Historic England

Our ref: PA00429817

Pre-application Advice

STANDEN HALL, WORSTON ROAD, PENDLETON, CLITHEROE, LANCASHIRE BB7 1PR

First Floor

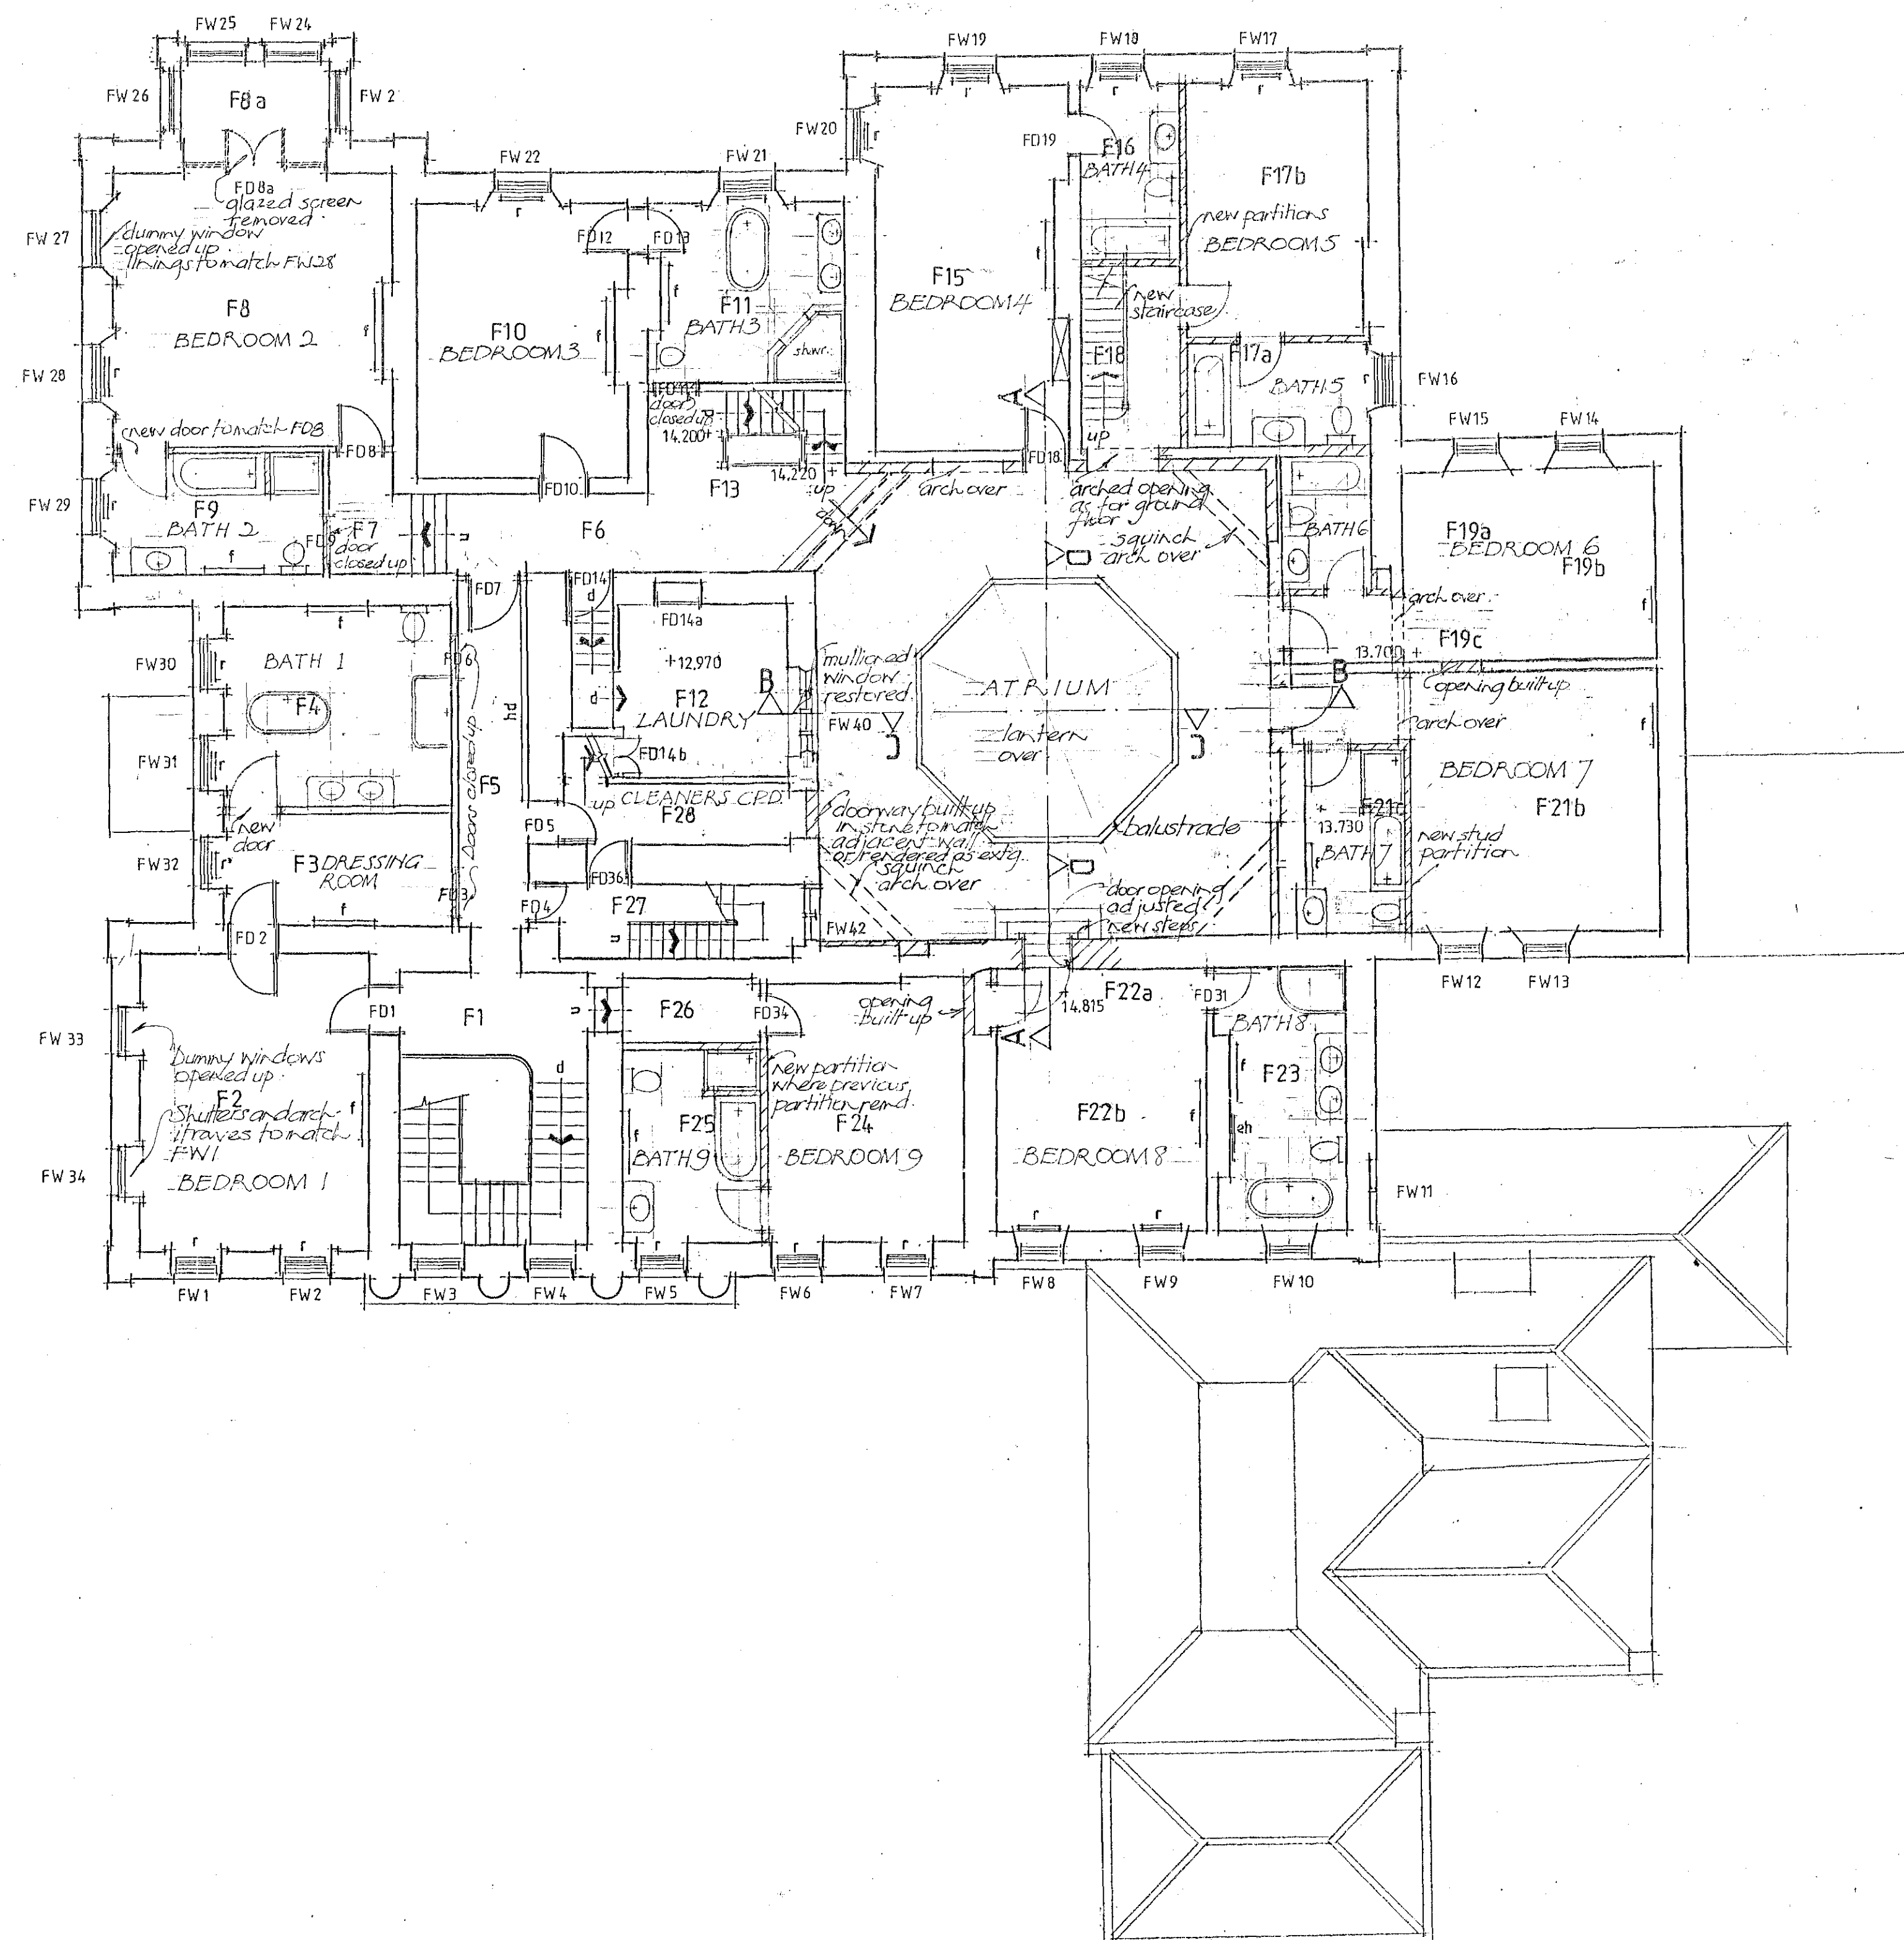
The majority of the works proposed to the existing family bedrooms relates to the aspiration to create en-suite bathrooms and in one case, a dressing room. As a whole these proposals are felt to be appropriate as doorways will be created where there is evidence of former doorways and walls are also to be reinstated. However, as discussed onsite, it is always preferable that when a doorway is to fall out of use due to a change in layout, that that doorway remains in situ, locked and potentially covered by studding on the interior face. The advantage of utilising this method is that the planned form of the building remains legible and the historic fabric remains in situ; as such the only element for our consideration is the change of use of the space, which is rarely likely to trigger concerns.

Another further point relates to consideration which is being given to removing a glazed screen from bedroom 2. My advice would be to retain this element, as its relative significance is not established and its presence does not affect the usability of the space. However, if there is still the desire to remove it, its interest and importance needs to be established and its removal justified.

Ground Floor

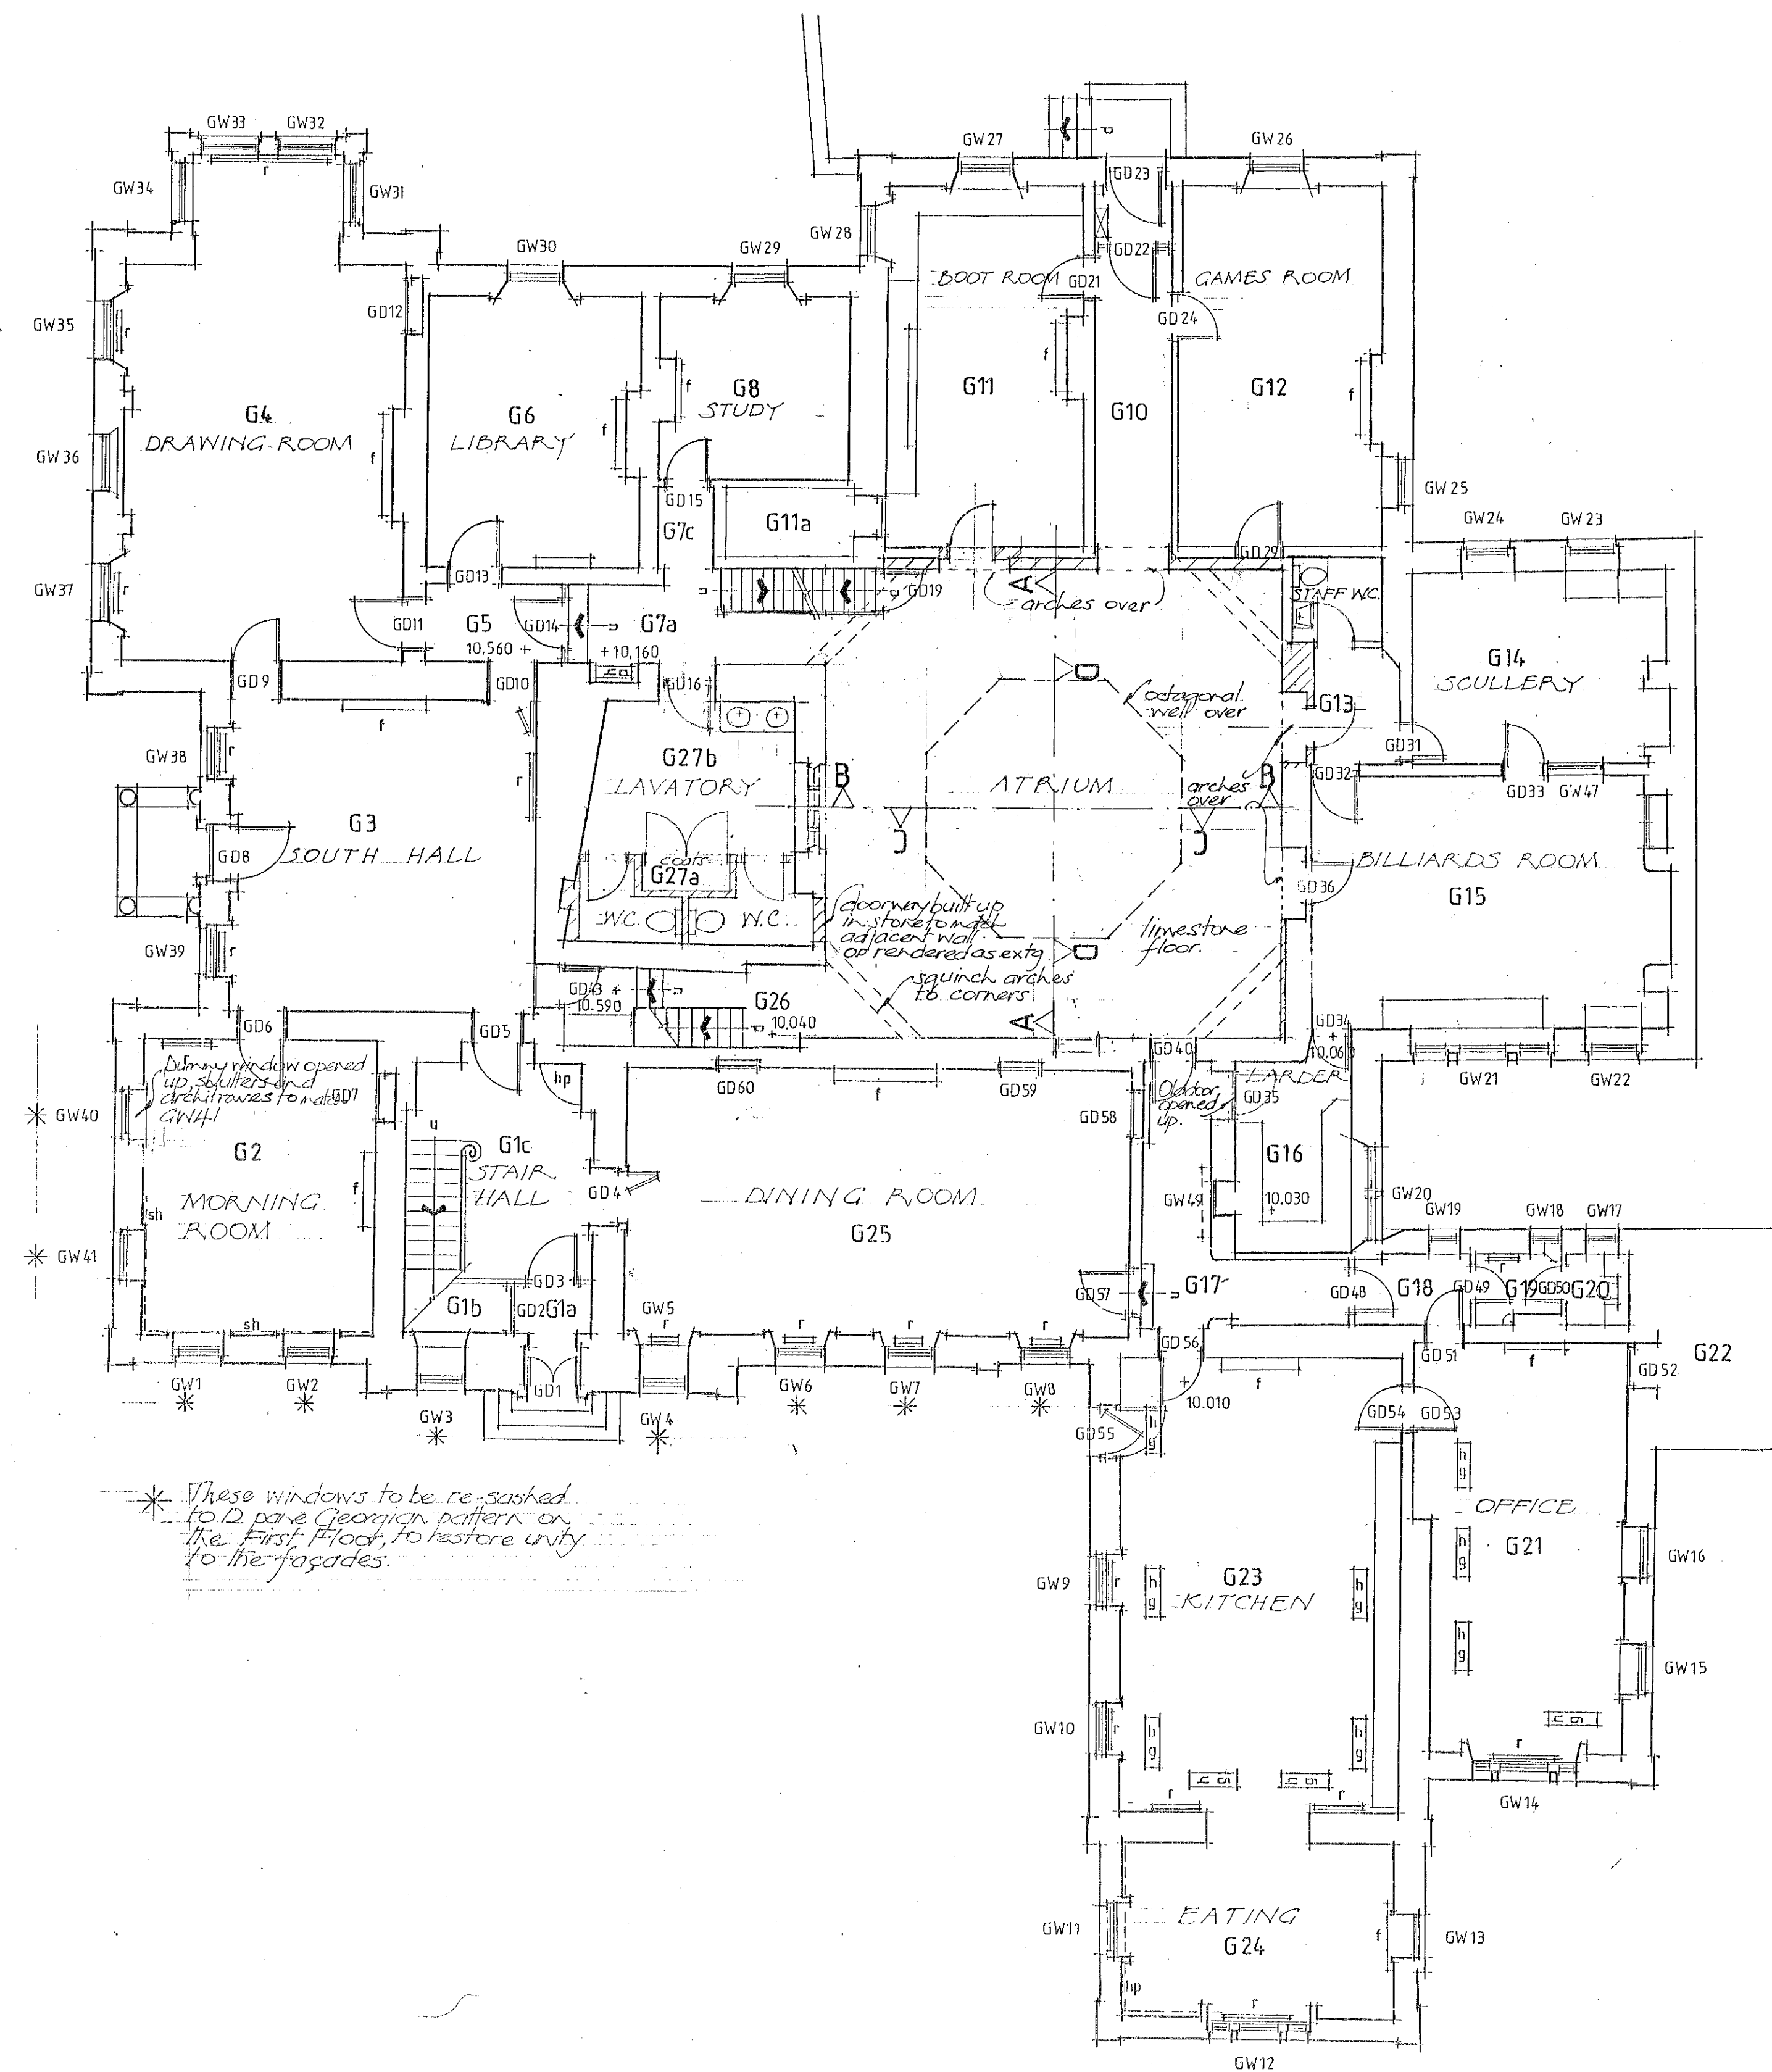
Setting aside the matter of the creation of an atrium area for consideration separately, the works proposed to the ground floor are quite minor in scale. The principle family rooms remain unaltered as part of the scheme and the changes proposed to most of the north wing are changes of use rather than physical alterations to the fabric. For example, the cabinets in the Butler's Pantry and the glazed partition between the existing kitchen and scullery will be retained as part of these changes of use, something we welcome as these elements do add to the overall interest and significance of Standen Hall.

With regard to the change of use of the Billiard Room to a family kitchen, the alteration is considered to result in a level of harm to the significance of the building, as the

However, in technical terms, as both the billiard table and the associated cabinets are freestanding, they are not considered to fall under the jurisdiction of listing, so can be relocated without the need for listed building consent. As such, it is only the intended use of the room which is for us to consider and we believe a kitchen can be accommodated in the space without harming the building, so we raise no concerns with the proposal.
